Our ref: OAKM002

**S96A OF THE TOWN & COUNTRY PLANNING ACT 1990 (AS AMENDED)
APPLICATION FOR NON-MATERIAL AMENDMENT TO PLANNING PERMISSION 3/2022/1158
FOR THE VARIATION OF CONDITION 2 TO AMEND THE APPROVED PLANS TO PLOTS
3,4,5,67,73 AND 74
LAND SOUTH OF ACCRINGTON ROAD, WHALLEY**

DRAWING TITLE
Kirkstone V2 Attached Garage House Type
Floor Plans & Elevations
DRAWING NUMBER
015KIRK-V2-AG-P03

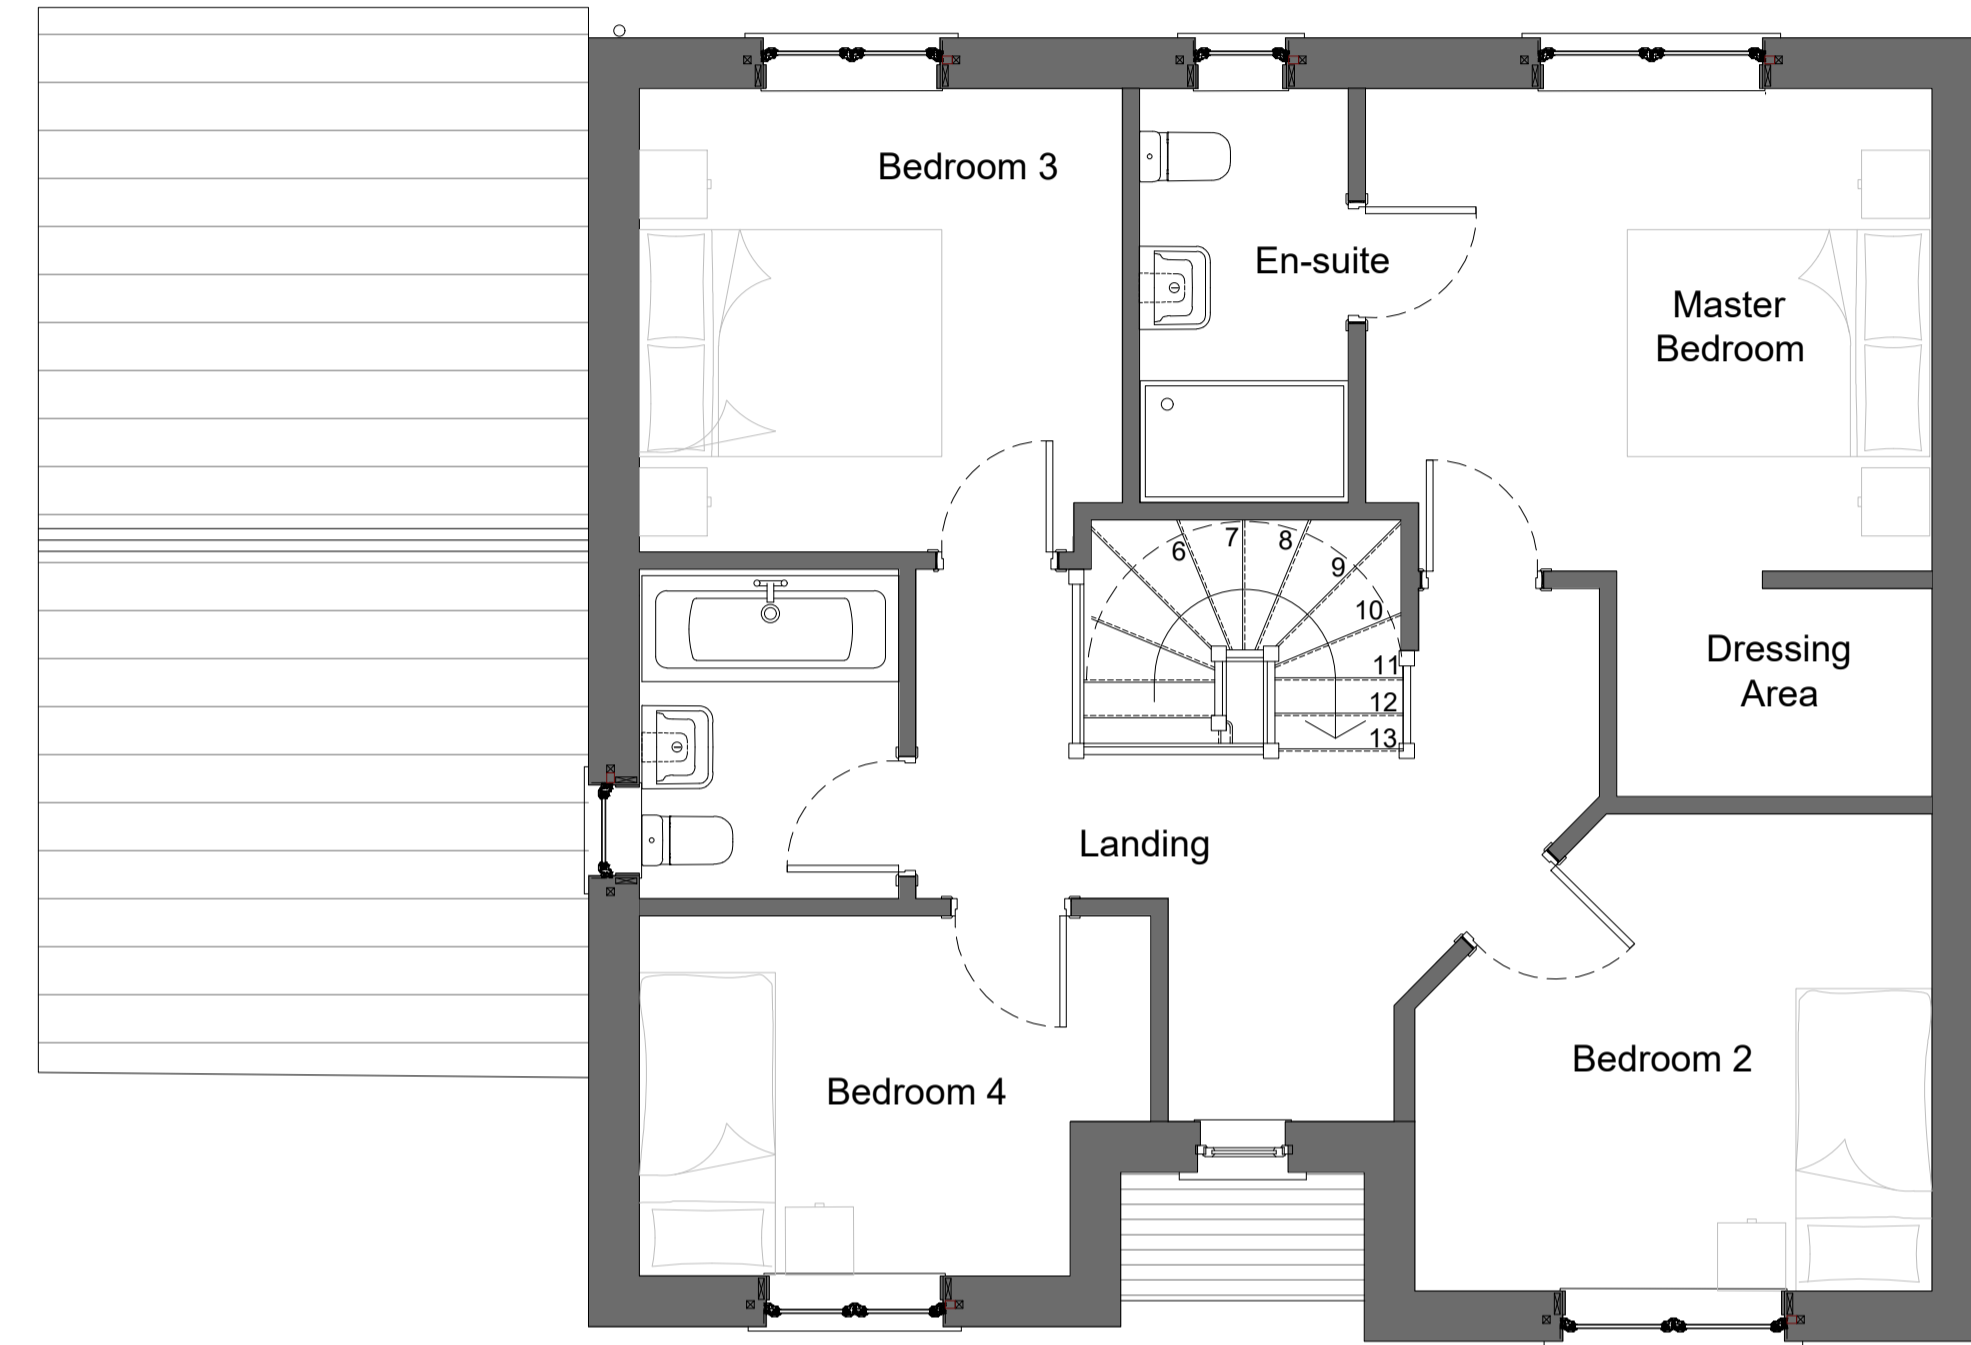
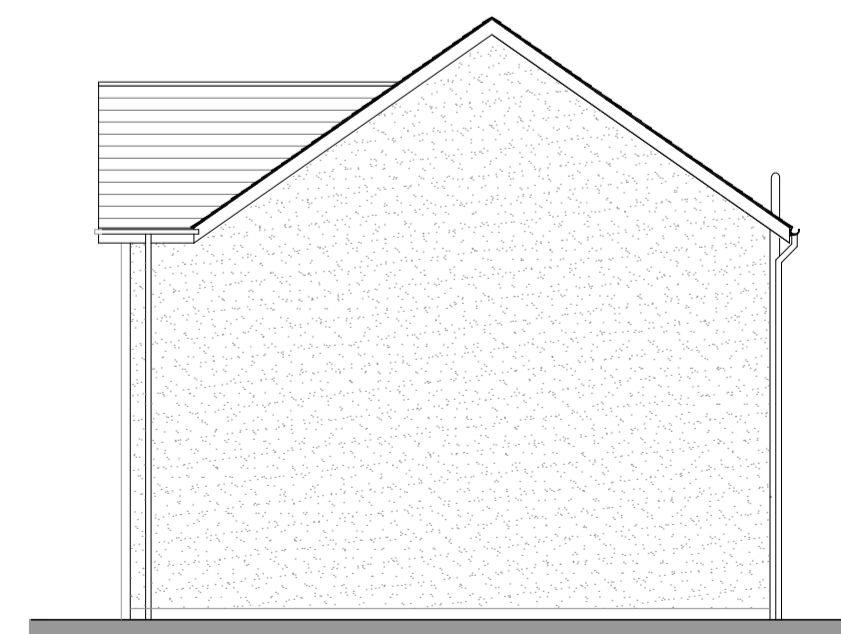
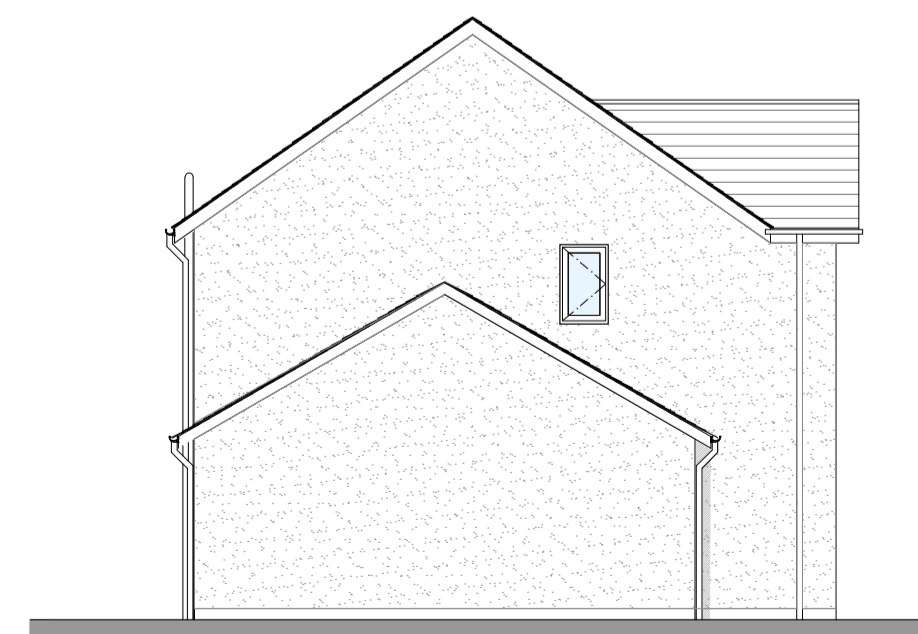
The second proposed revision would be to the Kirkstone housetype, whereby the two pediments to the building façade are slightly increased in width and the garage is realigned to run flush with the rear of the property (Plots 3, 4, 73 and 74).
